Re: Wat Buddhocothorn-Vibes Buddhist Temple
139 Madison St NE
Traffic Circulation Layout
Architect's Stamp dated 07-27-16 (K17D112)

The TCL submittal received 07-28-16 is conditionally approved for Building Permit. A copy of the stamped and signed plan will be needed for each of the building permit plans. Please keep the original to be used for certification of the site for final C.O. for Transportation.

TCL-101

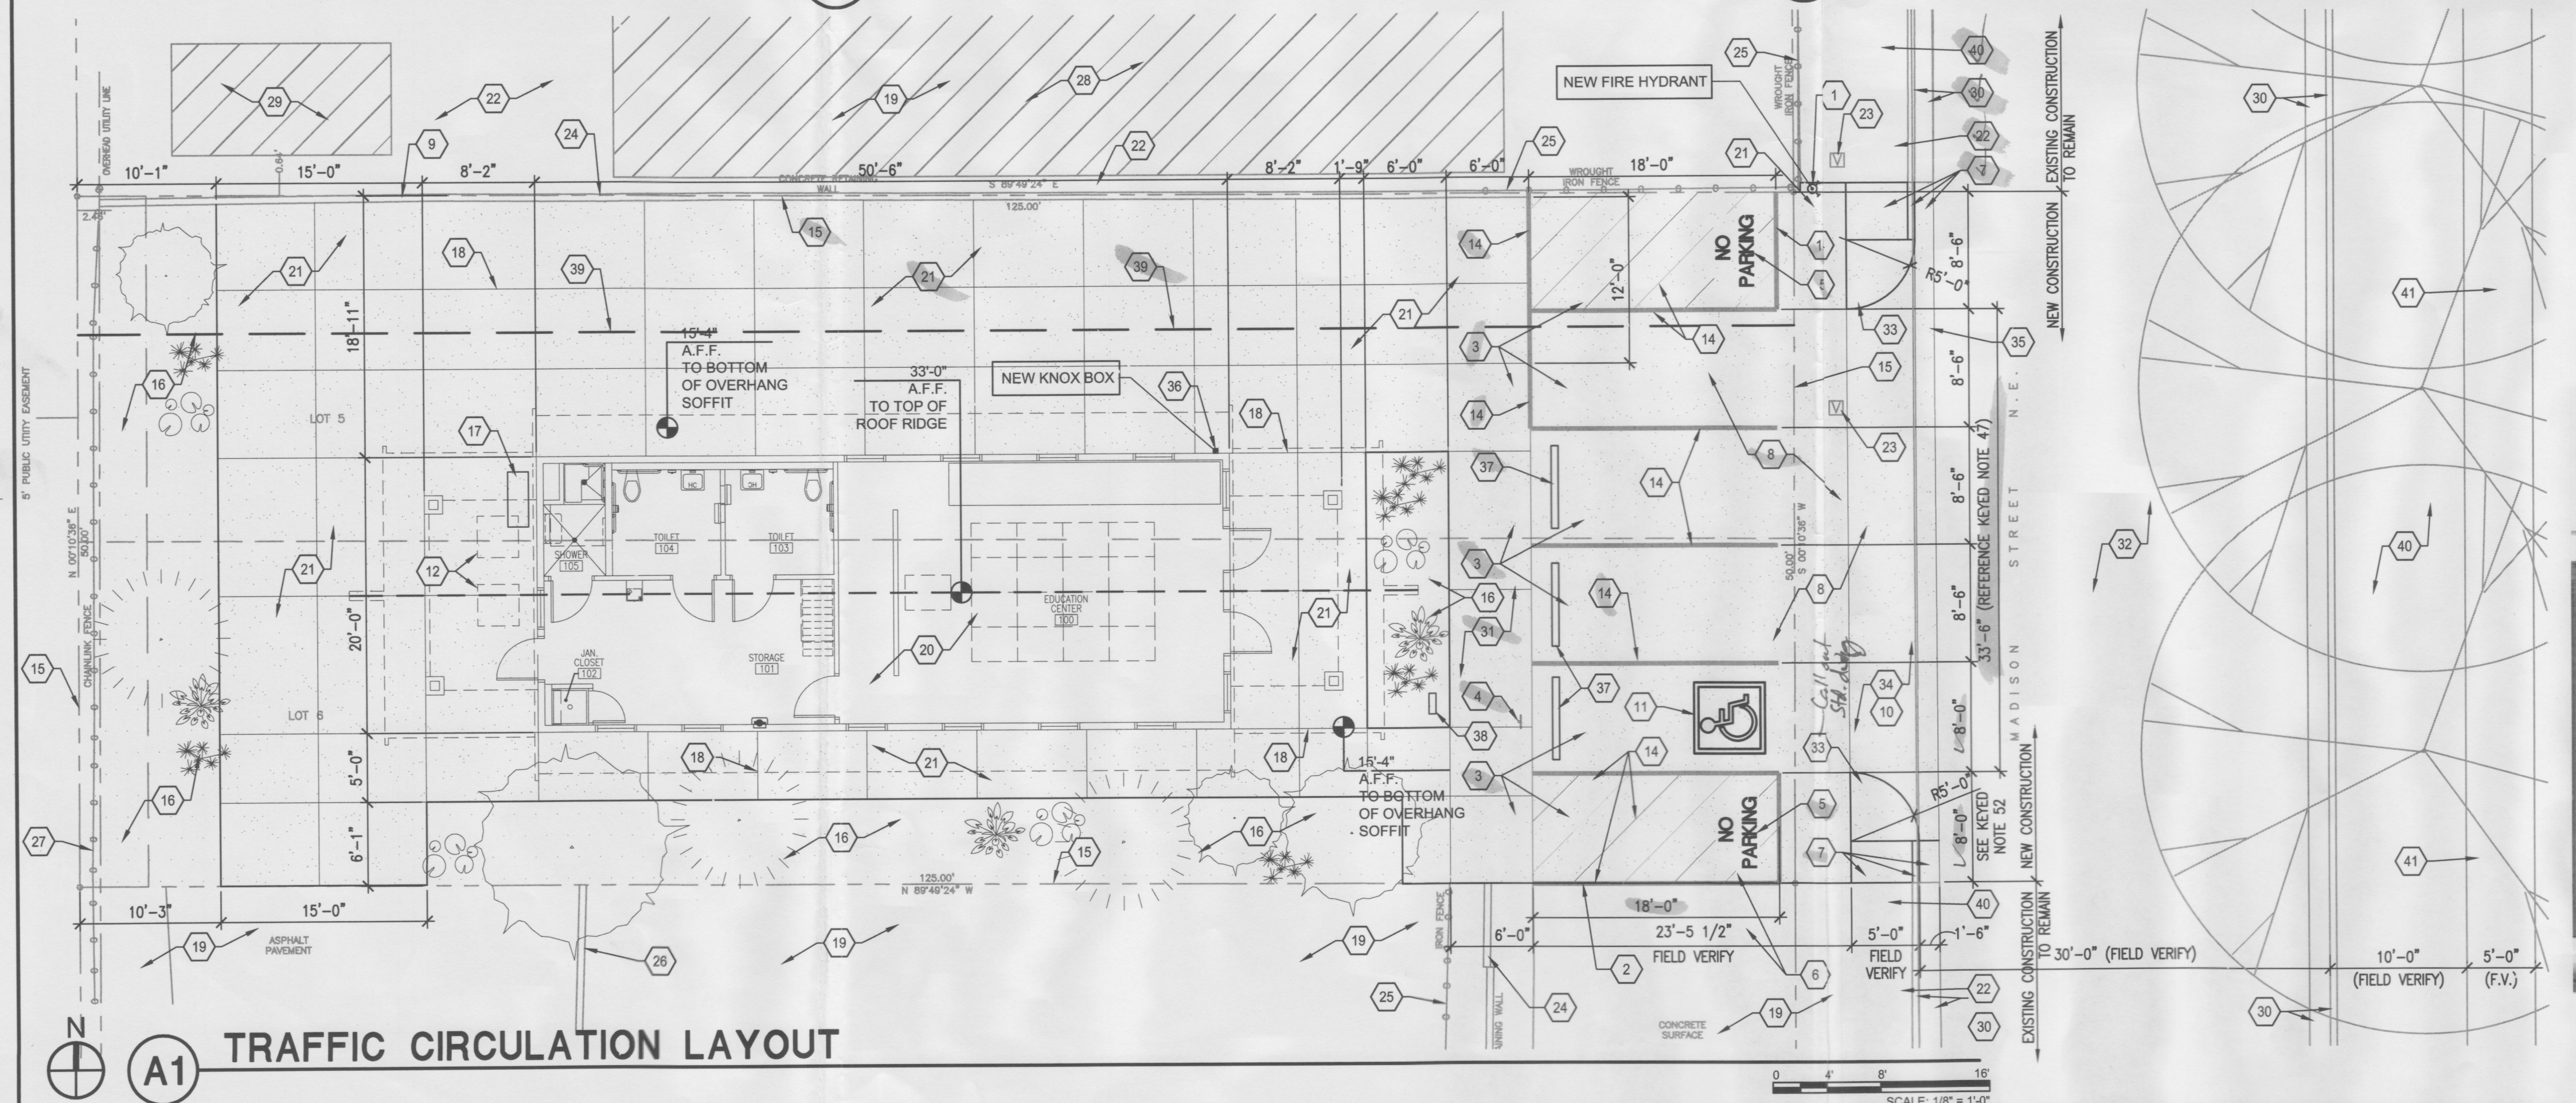
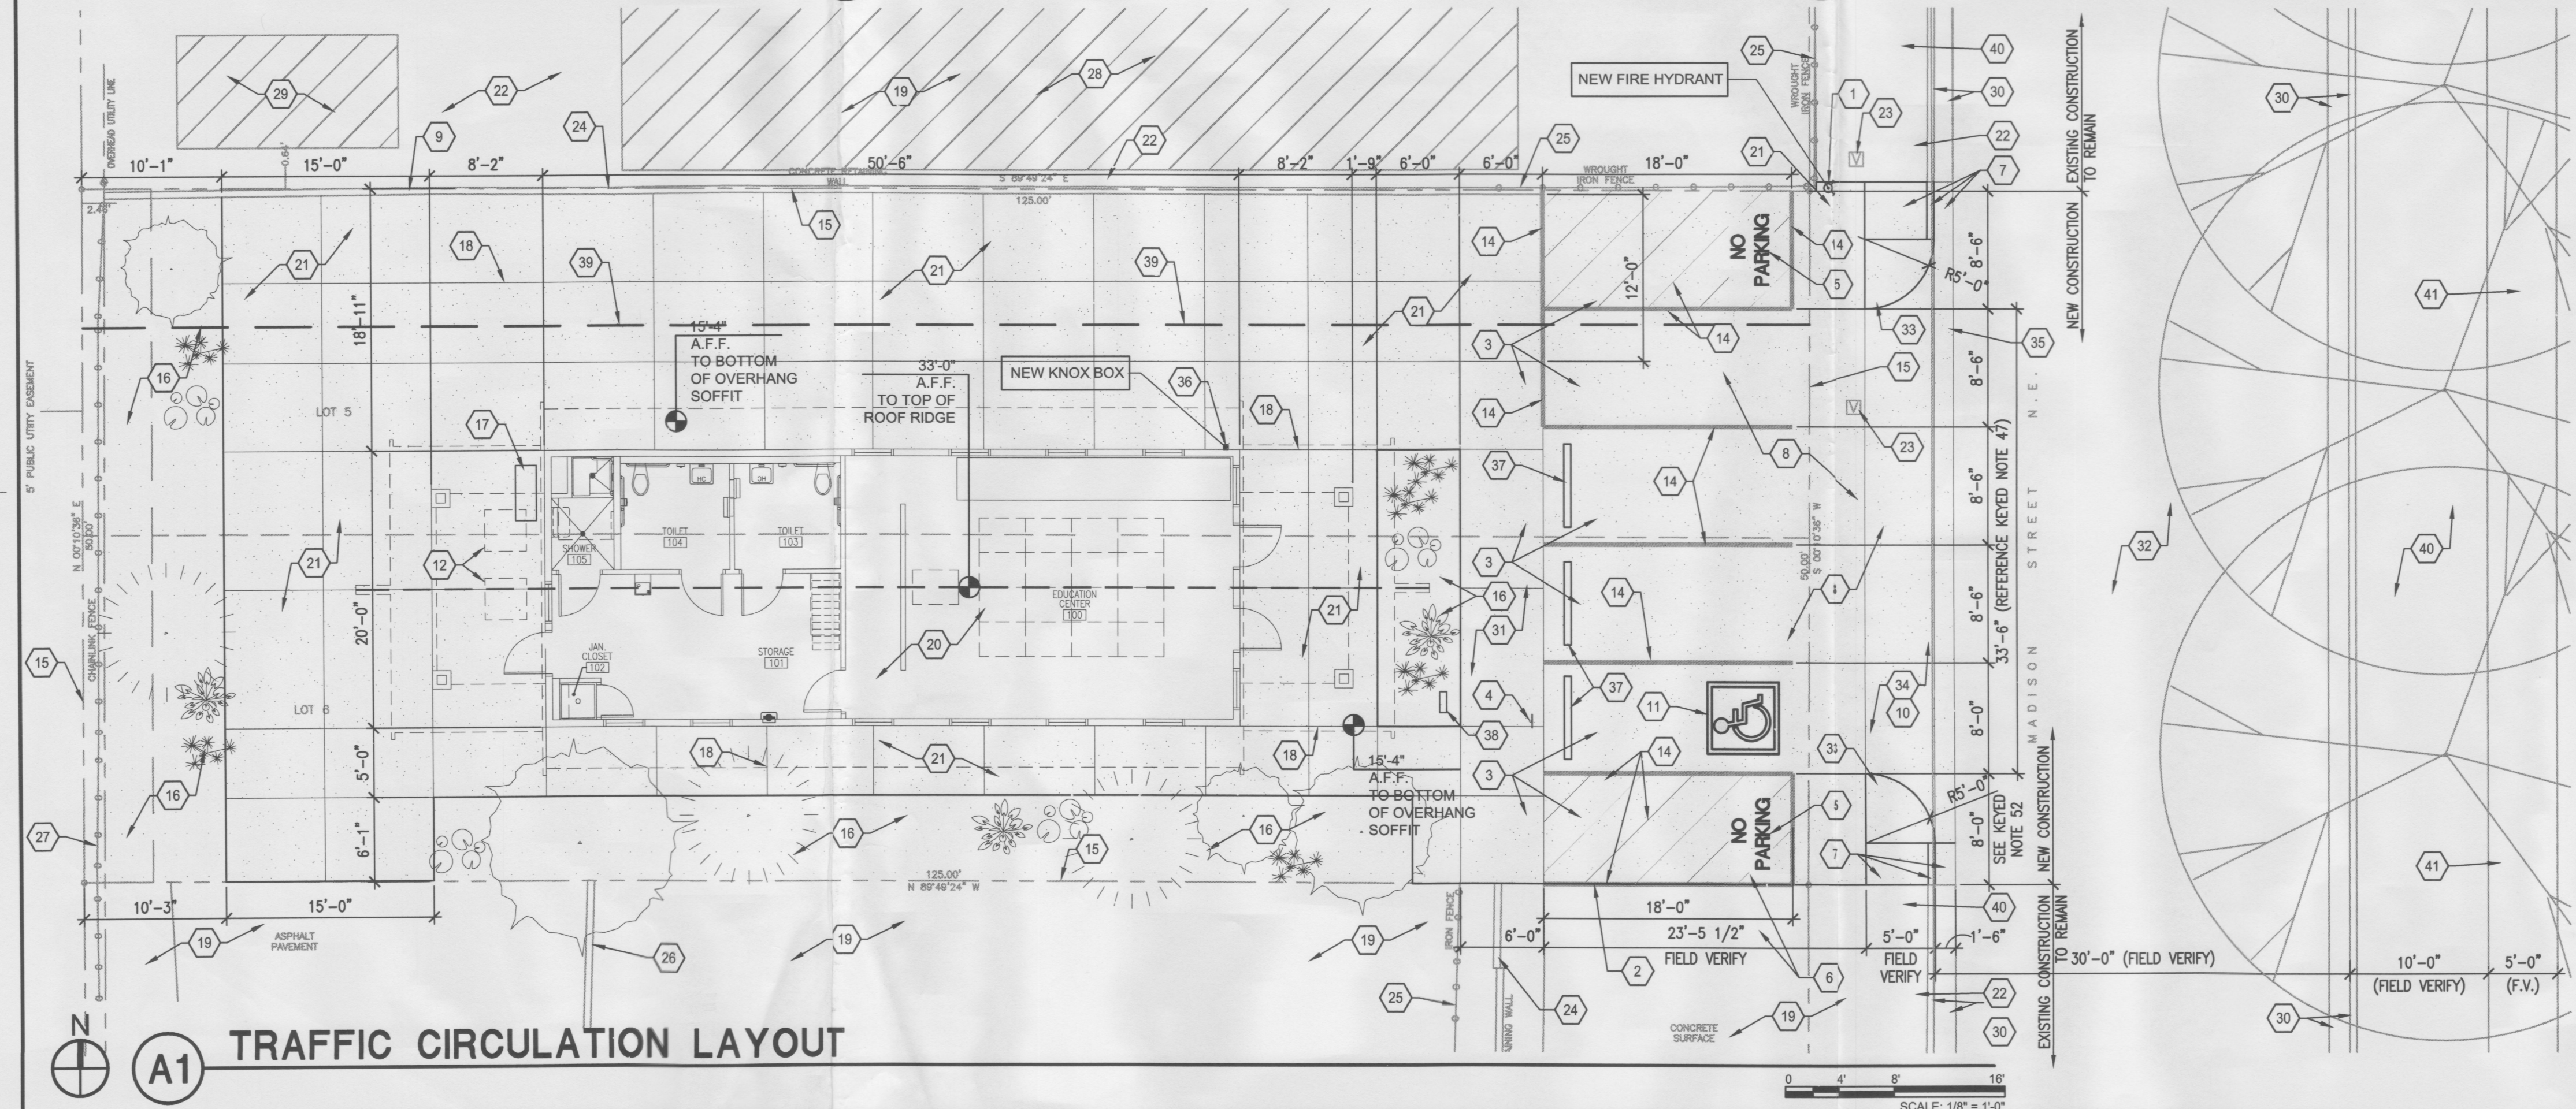
1. The ADA accessible parking sign must have the required language per 66-7-352.4C NMSA 1978 **"Violators Are Subject to a Fine and/or Towing."** Please call out detail and location of HC signs.
2. The ADA access aisles shall have the words **"NO PARKING"** in capital letters, each of which shall be at least one foot high and at least two inches wide, placed at the rear of the parking space so as to be close to where an adjacent vehicle's rear tire would be placed. (66-1-4.1.B NMSA 1978)
